**WELWYN HATFIELD BOROUGH COUNCIL  
EXECUTIVE DIRECTOR - PLANNING, PUBLIC PROTECTION AND GOVERNANCE**

**DELEGATED APPLICATION**

**Application No:** 6/2017/0363/HOUSE  
**Location:** 111 Eddington Crescent, Welwyn Garden City, AL7 4SX  
**Proposal:** Erection of a single storey side and rear extension and partial conversion of garage.  
**Officer:** Mr D Elmore

Drawing No: **4073-P01** Revision: **B**

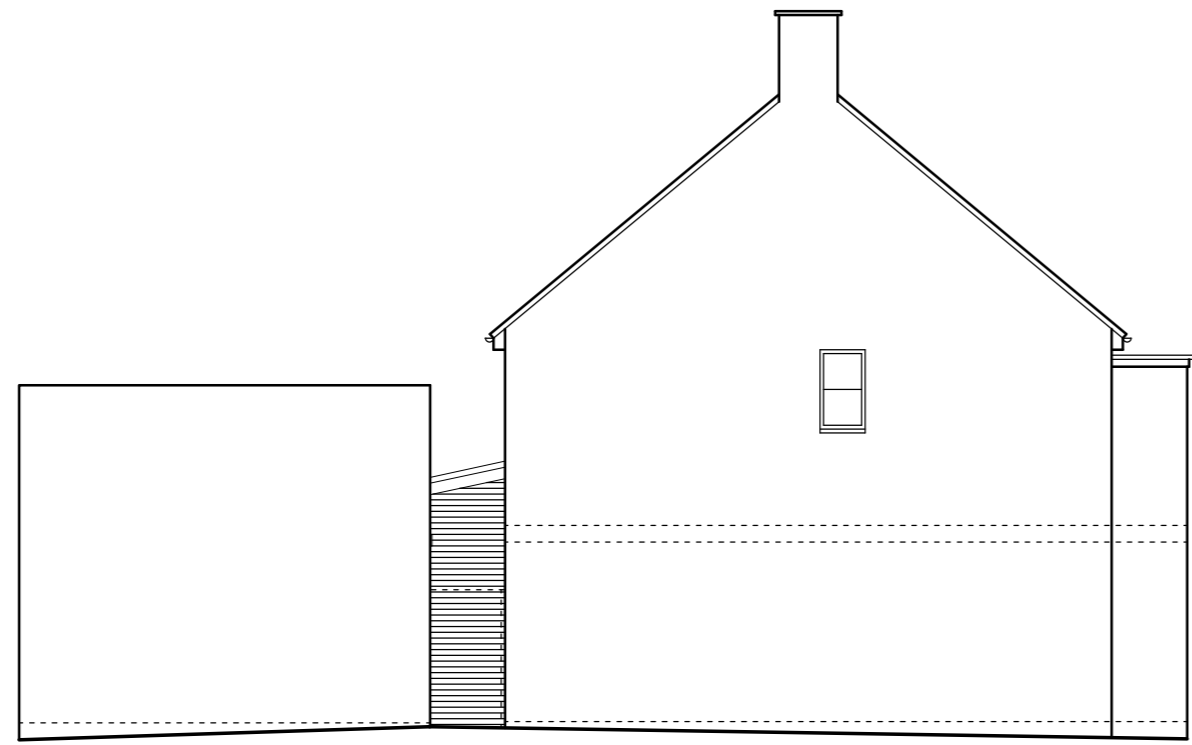
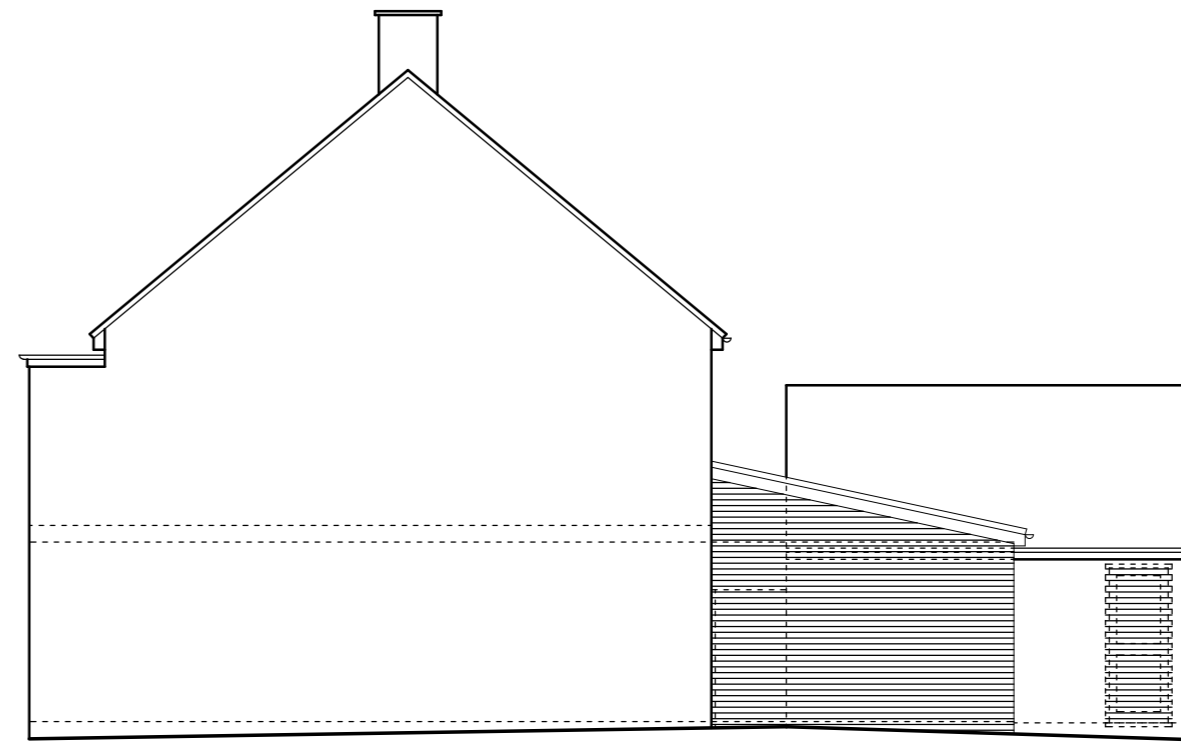
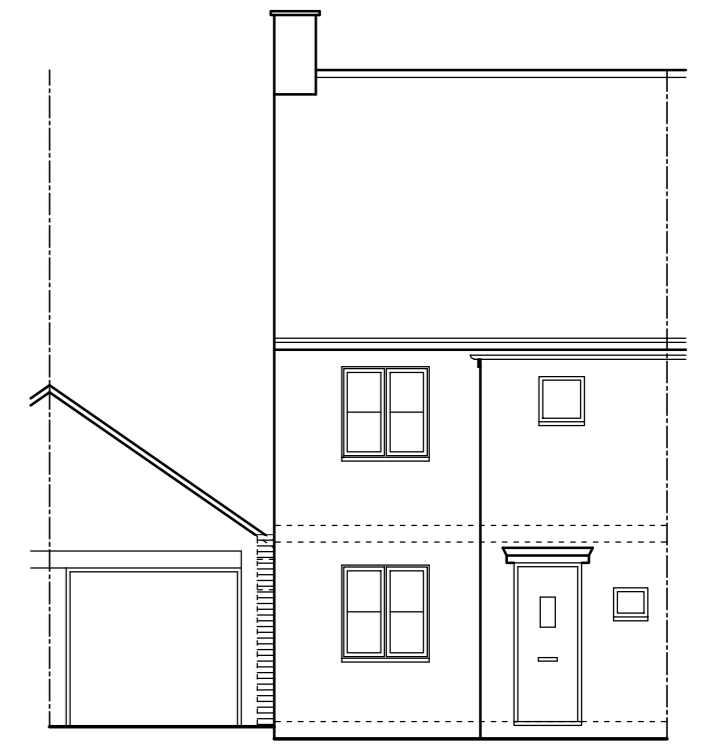
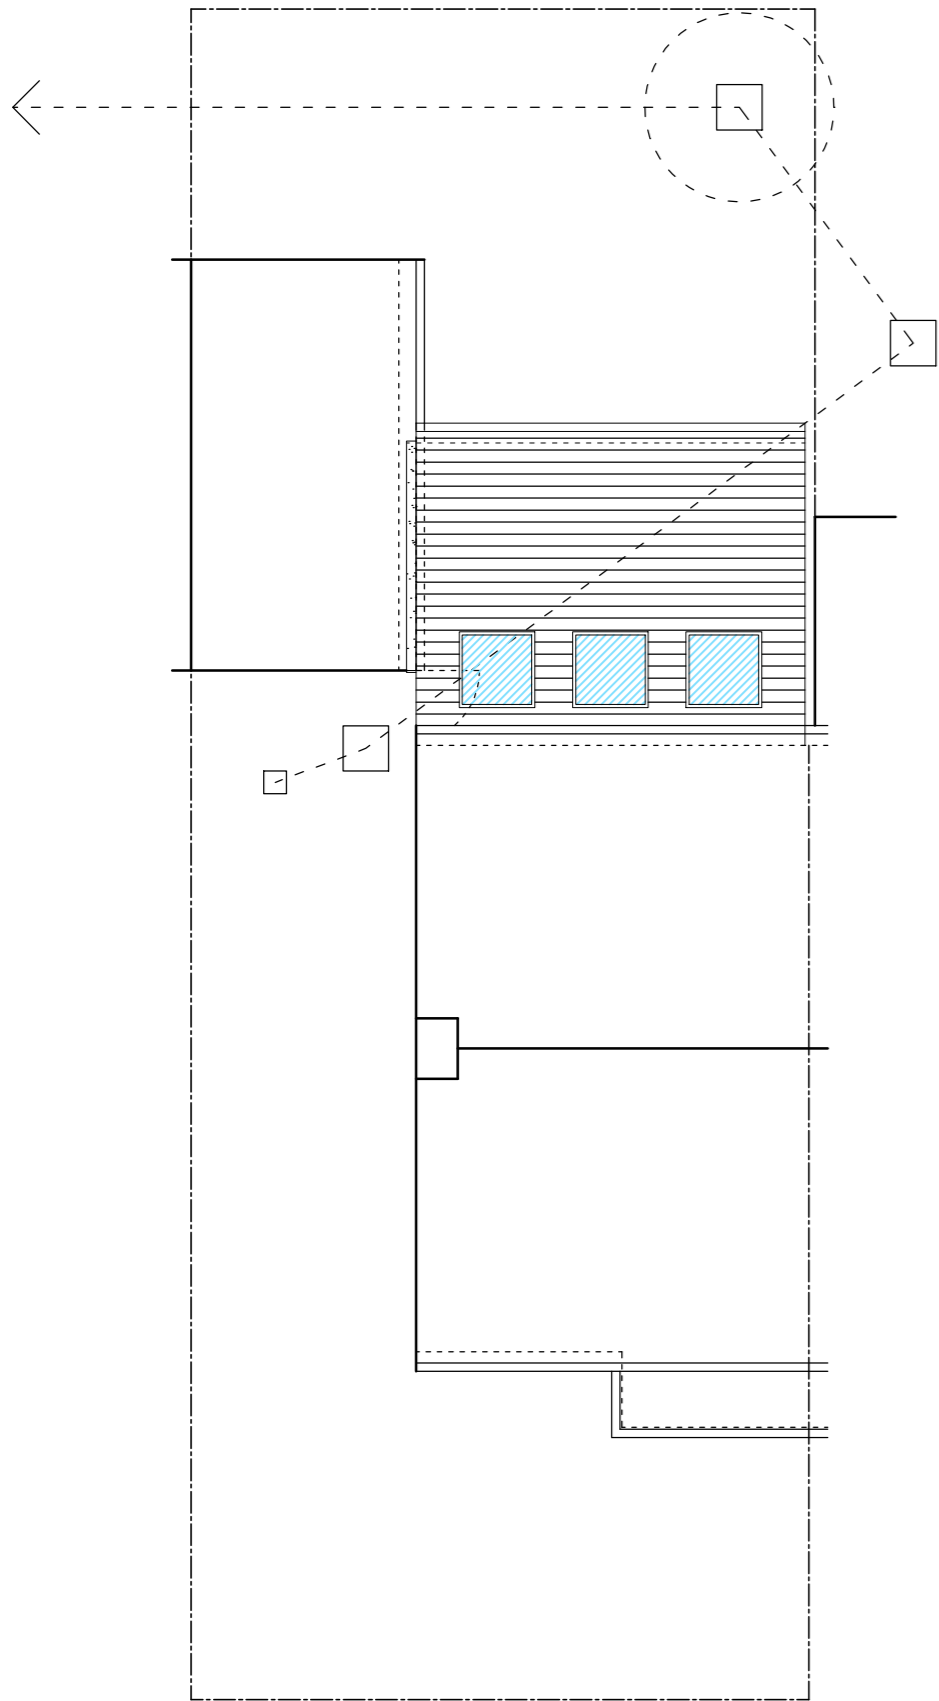
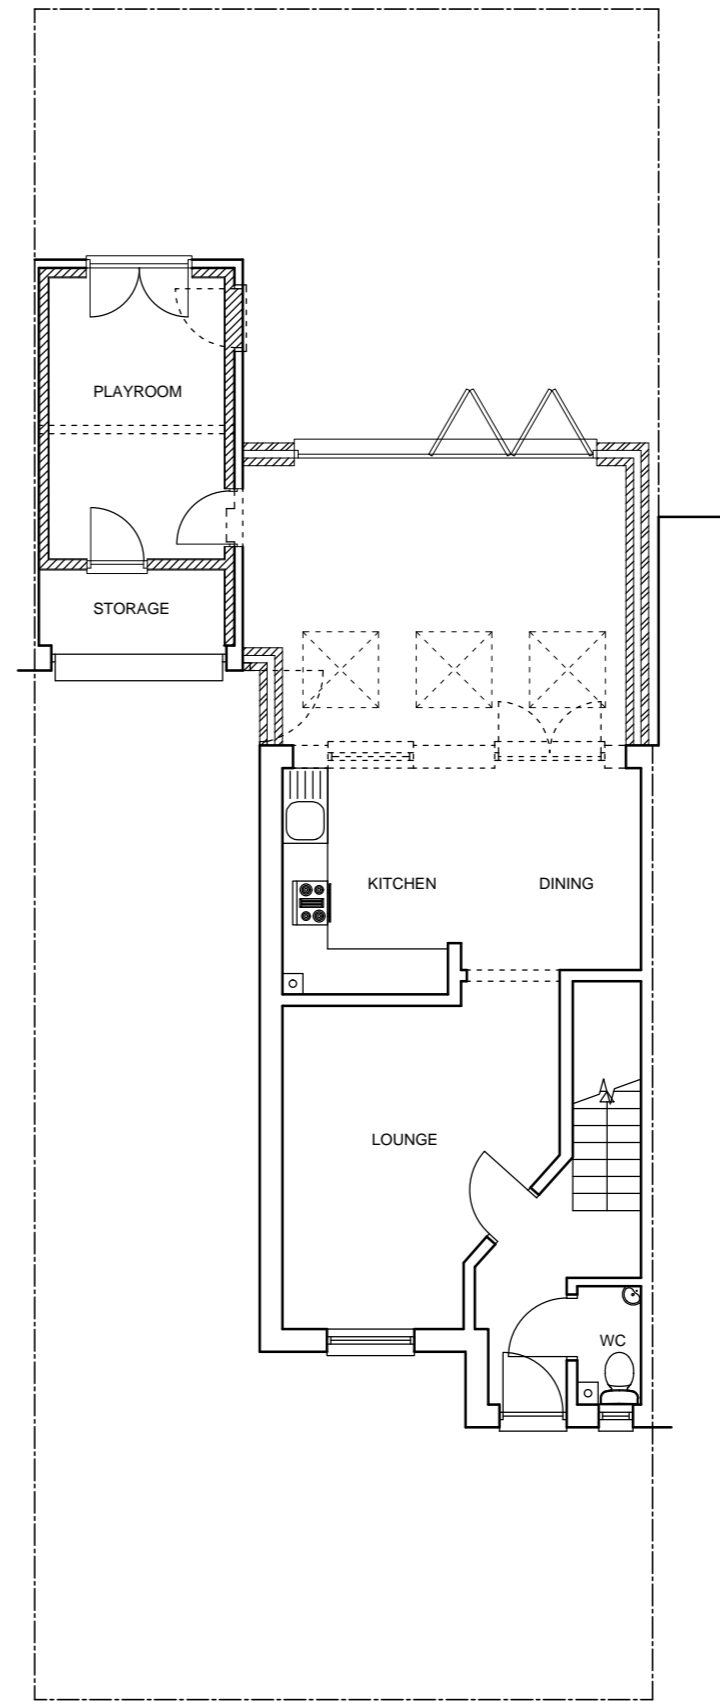
<input checked="" type="checkbox"/> Yes <input type="checkbox"/> No <b>Comment:</b> The proposed extension would feature a mono-pitch roof and measure 4 metres in depth, 2.8 metres to the eaves and 3.6 metres in height. It would extend 5.4 metres in width and be set in from the shared boundary with the adjoining neighbour by approximately 0.1 metres.  It is considered that this extension, through its single storey construction, scale and design would reflect the design and character of the dwelling and be subordinate in scale. This is subject to the external materials matching that of the dwelling and, in the event of a grant of planning permission, this can be secured through suitable planning condition.  This proposed extension would attach onto the existing detached garage which is also subject to habitable conversion under this application. This attachment would tie in neatly with the roof form of the garage and is thus considered acceptable in this regard.  The 4 metres depth of the proposed extension would result in a notable reduction in the footprint of the rear garden. It is however considered that the size of the rear garden would not be severely diminished nor would the extension reduce the space around the dwelling to such an extent that the dwelling would look cramped on its site.
